CITY OF ALBUQUERQUE

February 8, 2022

**Re: 98th & Bluewater Commercial Development
Traffic Impact Study
HT#K09D048, Dated 01/21/2022**

Figure 5: Proposed Site Scheme

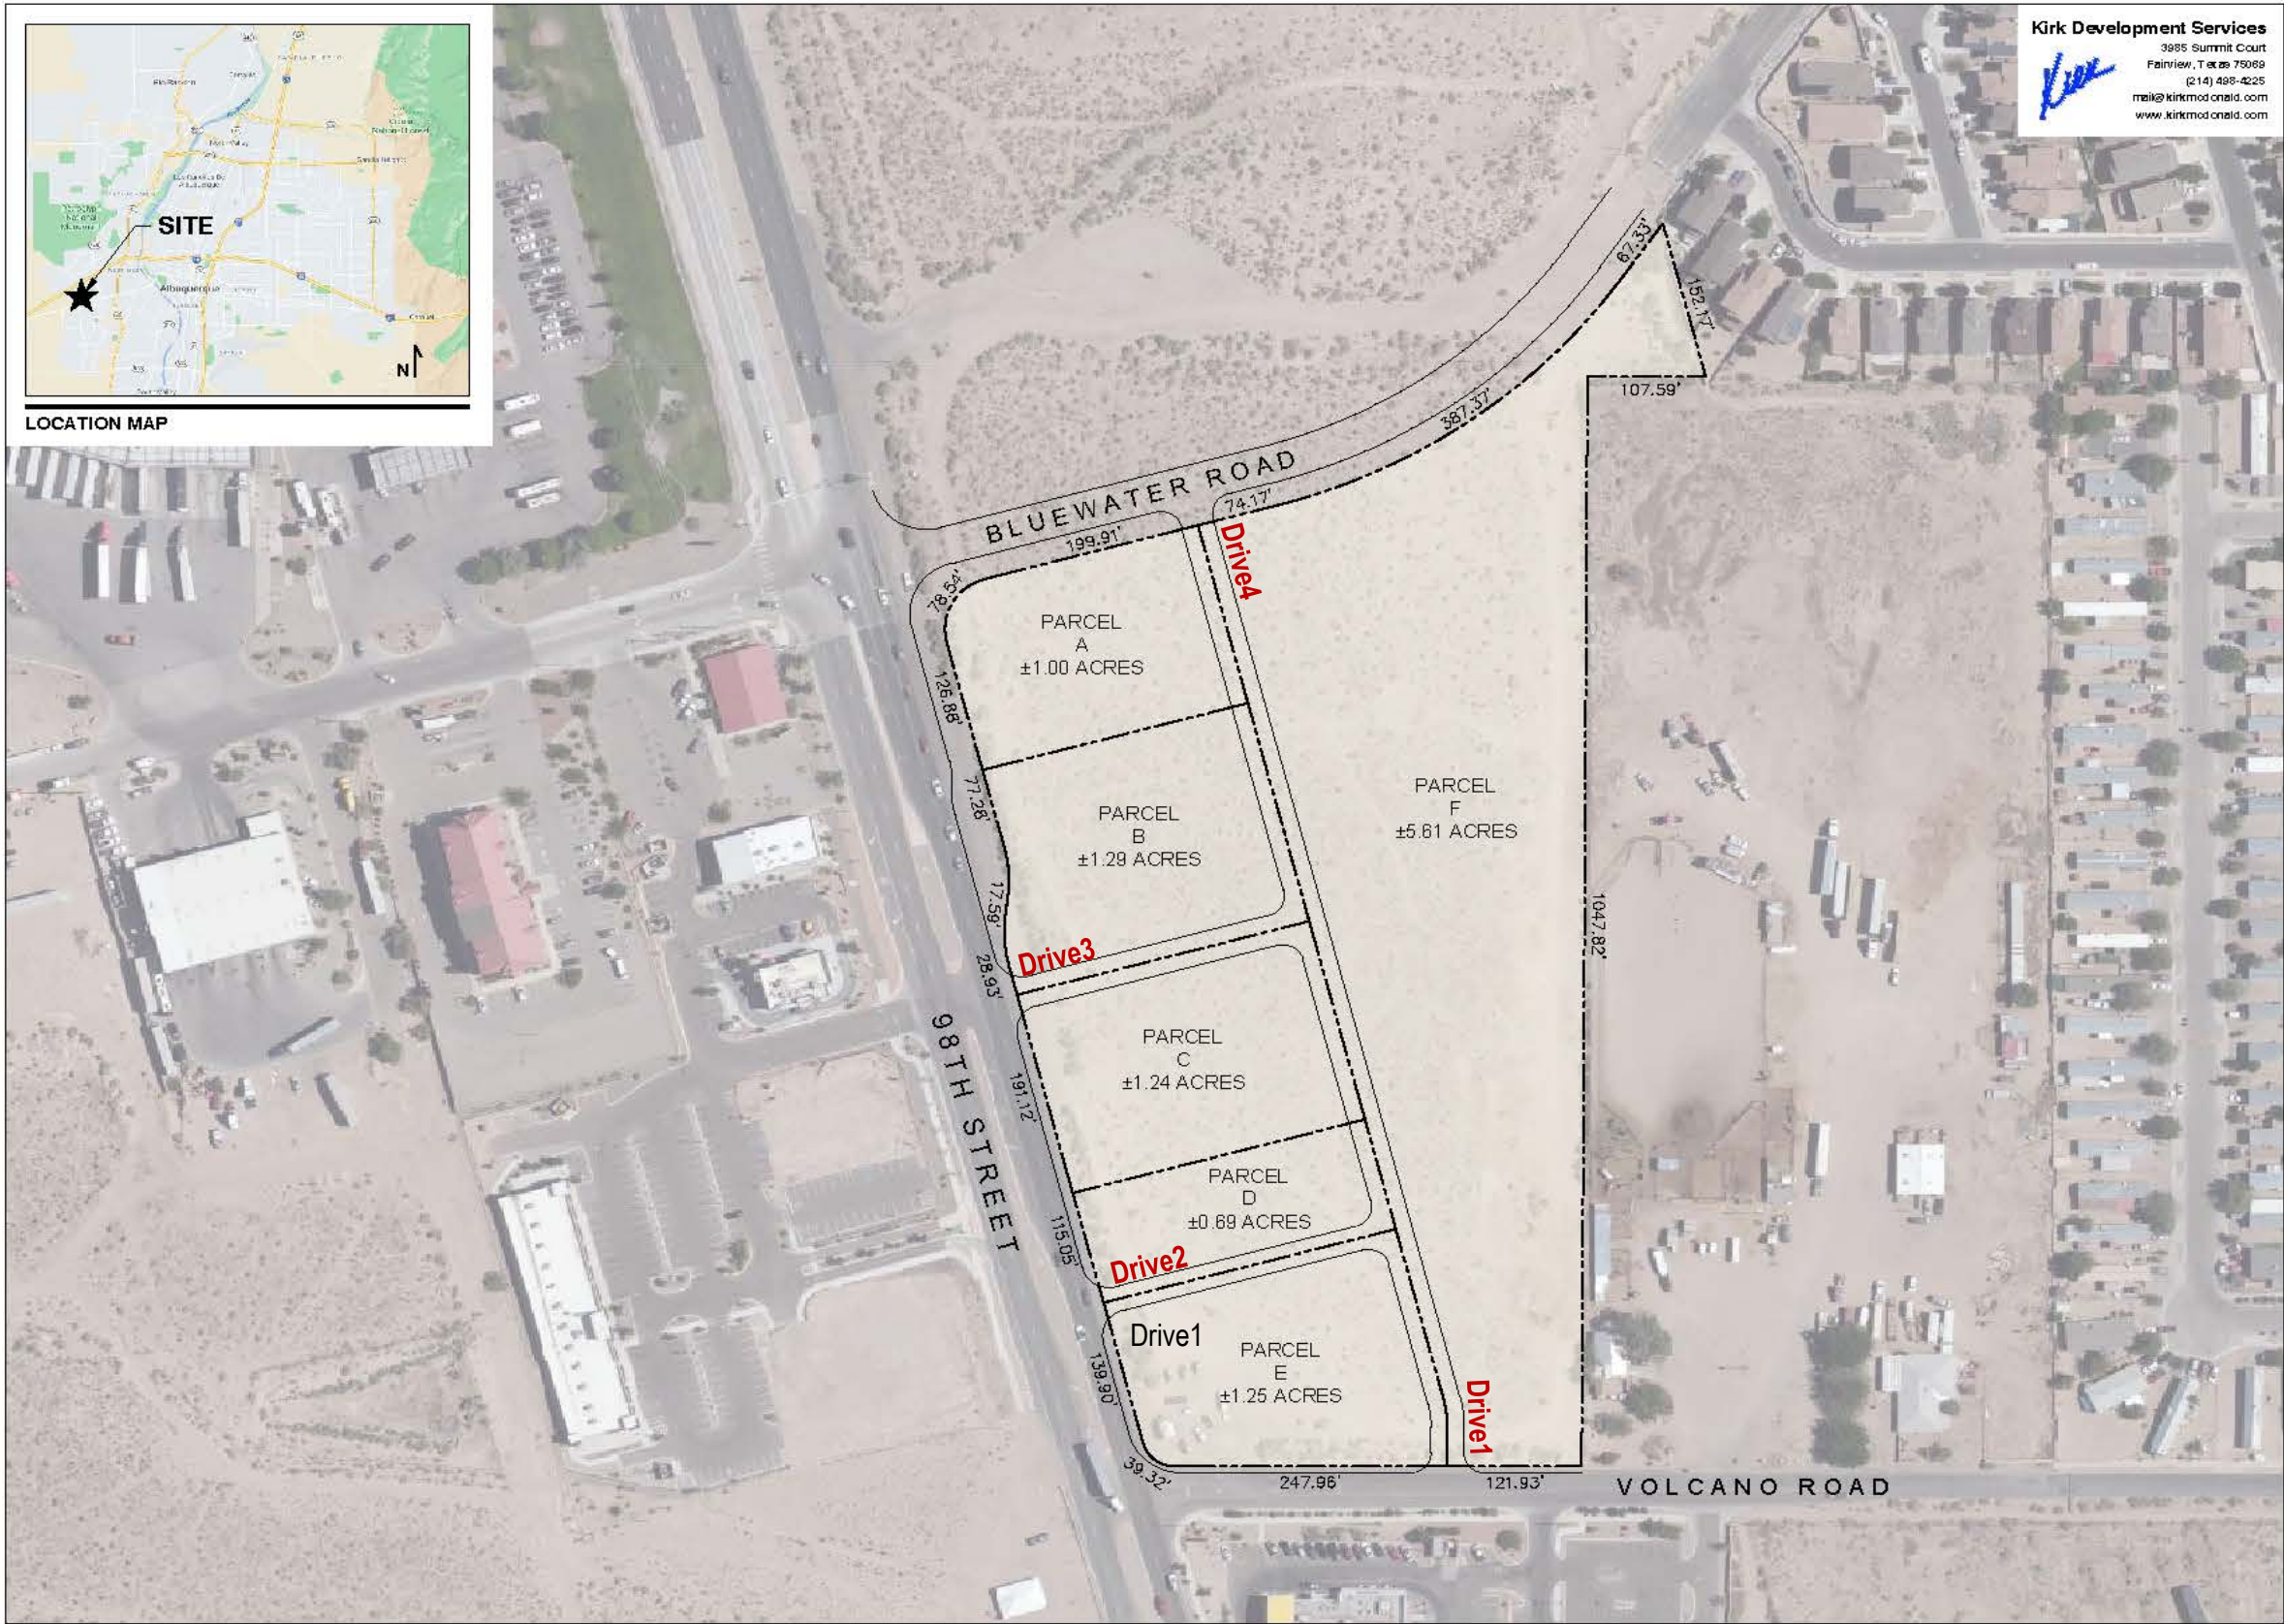
- Extension of the third northbound through (NBT) lane and 6' bike lane with 3' buffer along the property frontage from Bluewater Rd. to the Volcano Rd. return. This may necessitate the dedication of right-of-way (ROW) to accommodate the proposed roadway geometry.

- Addition of a northbound right-turn (NBR) lane at 98th/Bluewater Rd. and accommodation of trucks.
- Installation of buffered sidewalk along the property frontage.

- Provision of a southbound left-turn (SBL) lane on 98th St. at Site Driveway 3.
- Other improvements to 98th St. at Central Ave. will be required to address background traffic growth; a fair share contribution from the developer should be established based on the proportion of site traffic contributed to this intersection.

- At 98th Street and Bluewater/Avalon the development shall extend the southbound left turn lane to meet queue plus storage as calculated in this report.

- Install signal detection for 98th Street northbound and southbound for all lanes.
